**RE: Proposed Tirawley Windfarm Project, Strategic Infrastructure Development
Application to An Coimisiún Pleanála under Section 37(E) of the Planning and
Development Act 2000 (as amended)**

Case Reference ACP PAX16.324258

ACP- PAX16.324258: Proposed Development of the construction of Tirawley Windfarm consisting of 16 no. wind turbines, including a 110kV sub-station on site, an energy storage system in the form of a battery array located within container units and all associated infrastructure

Plate 12.9: Map showing selected representative viewpoints within the study are (Refer to Volume III Figure 12.9 for larger scale version)

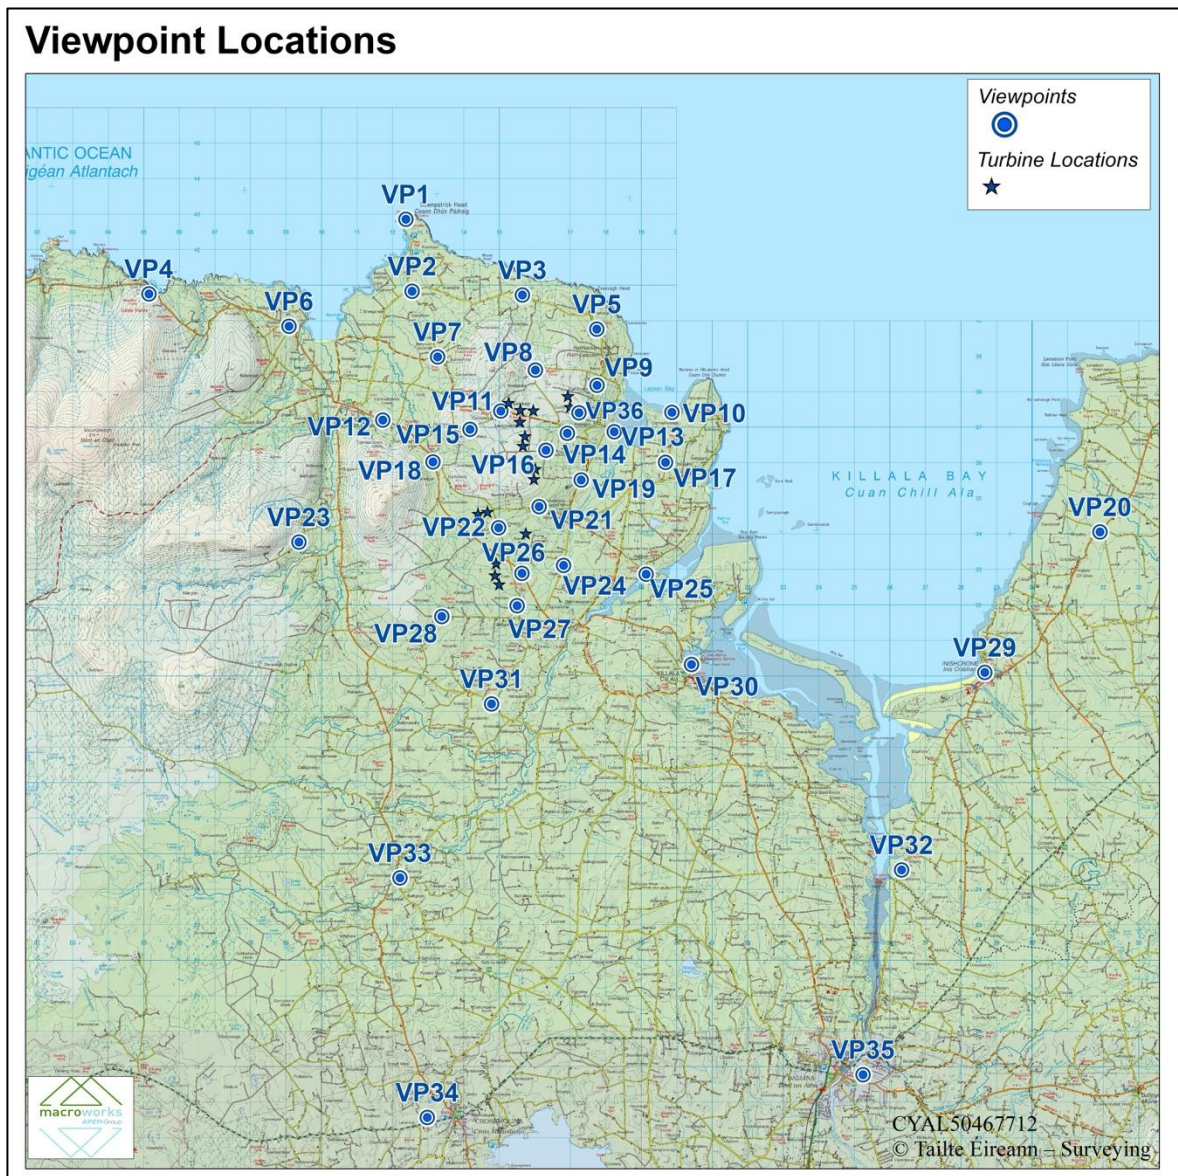
In Table 12.9 the Céide Fields was selected as view point VP4. The photographs used for the Landscape and Visual Impact Amenity Viewpoint Photomontage Booklet Book 1 images were taken from just outside the Visitor Centre building on the lowest level of the boardwalk guided tour route. In practice, the best location to view the surrounding landscape from the guided tour route is at the highest upslope part of the route (marked X1 on Figure 2 below) where the guides will point out the extent of the Neolithic field systems from Belderrig to Lacken. Lacken is directly beyond where the turbines would be in view. The visual impact from the turbines would also be greater from this location. Similarly, more visitors would admire and photograph the views from the rooftop viewing platform of the Visitor Centre) than from where the photographs were taken. This location is considerably higher than the level of the photograph with a greater visual impact from the turbines. Perhaps the most photographed view from Céide Fields is from the cliff edge viewing platform Discovery Point on the Wild Atlantic Way (marked 3 on map) looking eastwards across the sea. This takes in the dramatic Signature Discovery Point of Downpatrick Head and also the skyline with the proposed turbines. The view from the platform includes a wider section of the hill on the eastern horizon than the photograph in VP4 where it is more

VP4 is classified with a Very High visual receptor sensitivity but with a Low-negligible magnitude of visual impact and a visual impact significance of Slight / Negative / Long Term. The OPW disagree with these assessments of impacts. On page 57, it is stated, *"two turbine nacelles and partial views of the blade sets of up to four further turbines will be visible, rotating along the skyline ridge. Nonetheless, the turbines are viewed as small-scale background features and are well offset from the more susceptible coastal context viewed further to the north. As a result, the residual significance of effect was deemed Slight, which is principally influenced by the sensitivity of the visual receptor as opposed to any notable magnitude of visual effect."* The most significant view from the Céide Fields is the view of the entire sweep of prehistoric field systems under blanket bog that extend from Belderrig in the west to Lacken in the east. This is what consistently overawes visitors and it is the only way to appreciate the sheer scale of the archaeological landscape. These turbines will be visible on the horizon exactly over the eastern limit to the visible area of bog-covered prehistoric landscape. They will also

Plate 12.10: Cumulative ZTV Map (Tip Height -135m) for Tirawley Wind Farm identifying the potential intervisibility of the proposed Wind Farm and all other existing and consented wind farms within the study area (See Volume III Figure 12.10 for larger version).

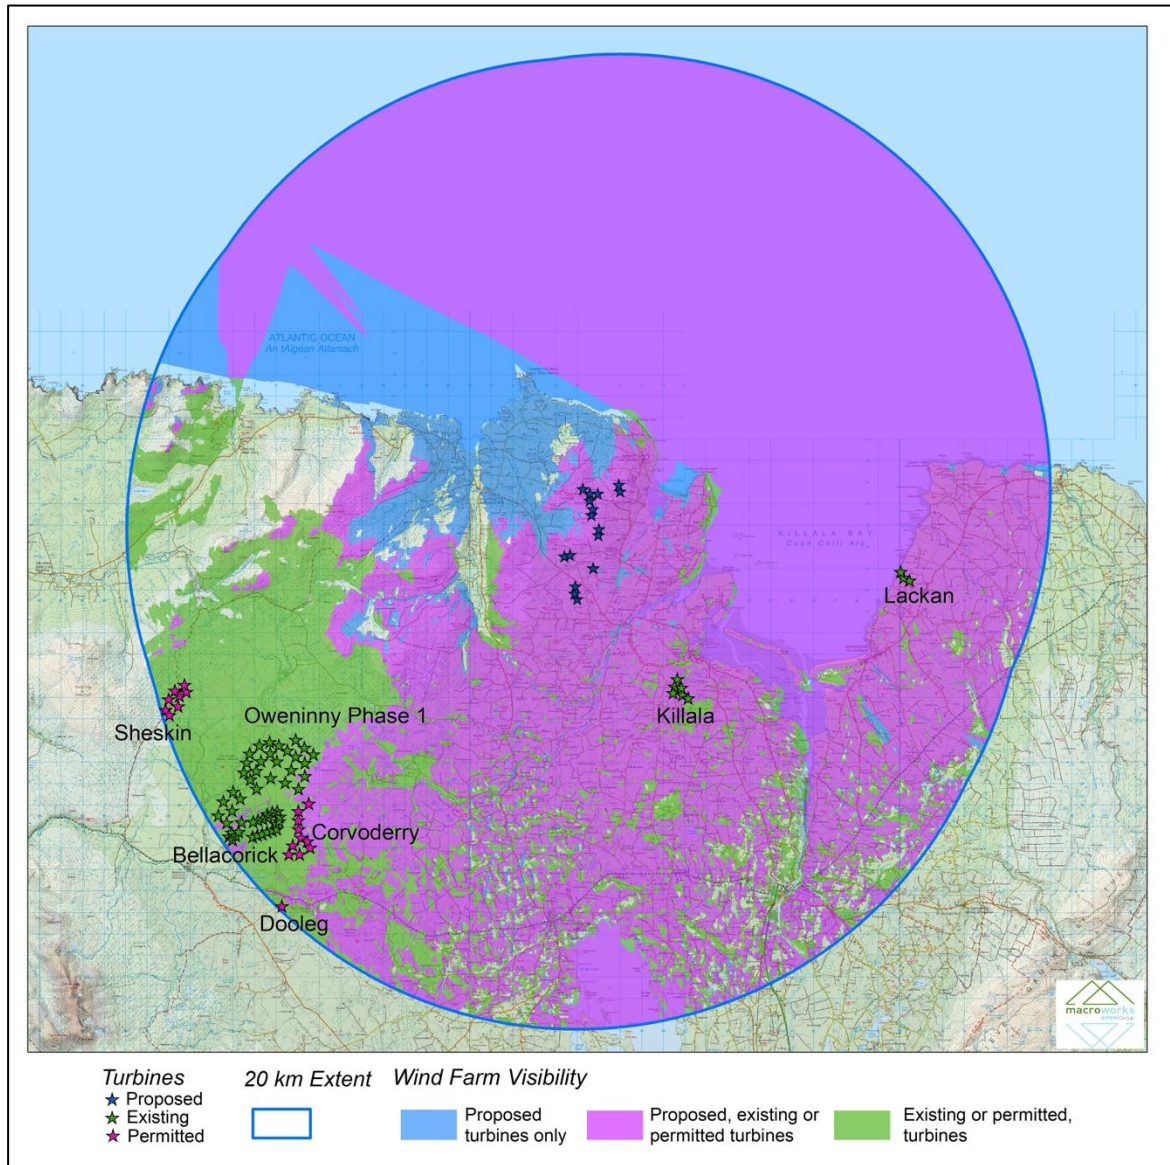
The LVIA states that there is predicted indirect *significant* effect at operational stage on Rathfran Abbey (National Monument Ref. 269). In an apparent reference to the other four National Monuments in this location, it states that ‘these sites... are located at prominent elevated or riverine positions within the landscape. There are no mitigation measures to ameliorate these indirect operational stage effects on setting.’ The OPW interprets this statement as meaning that all of the five National Monuments located 1.5km-4.5km from the windfarm have full visibility of all of the turbines. The OPW notes that the Killala Community Windfarm is already in existence.

VPs 24 and 25 are the closest approximate locations of the above referenced National Monuments. The lack of photomontages from these heritage receptors makes it difficult to assess the impact. The planning documentation asserts that apart from Rathfran Abbey all of the other sites are inaccessible. This is not correct.
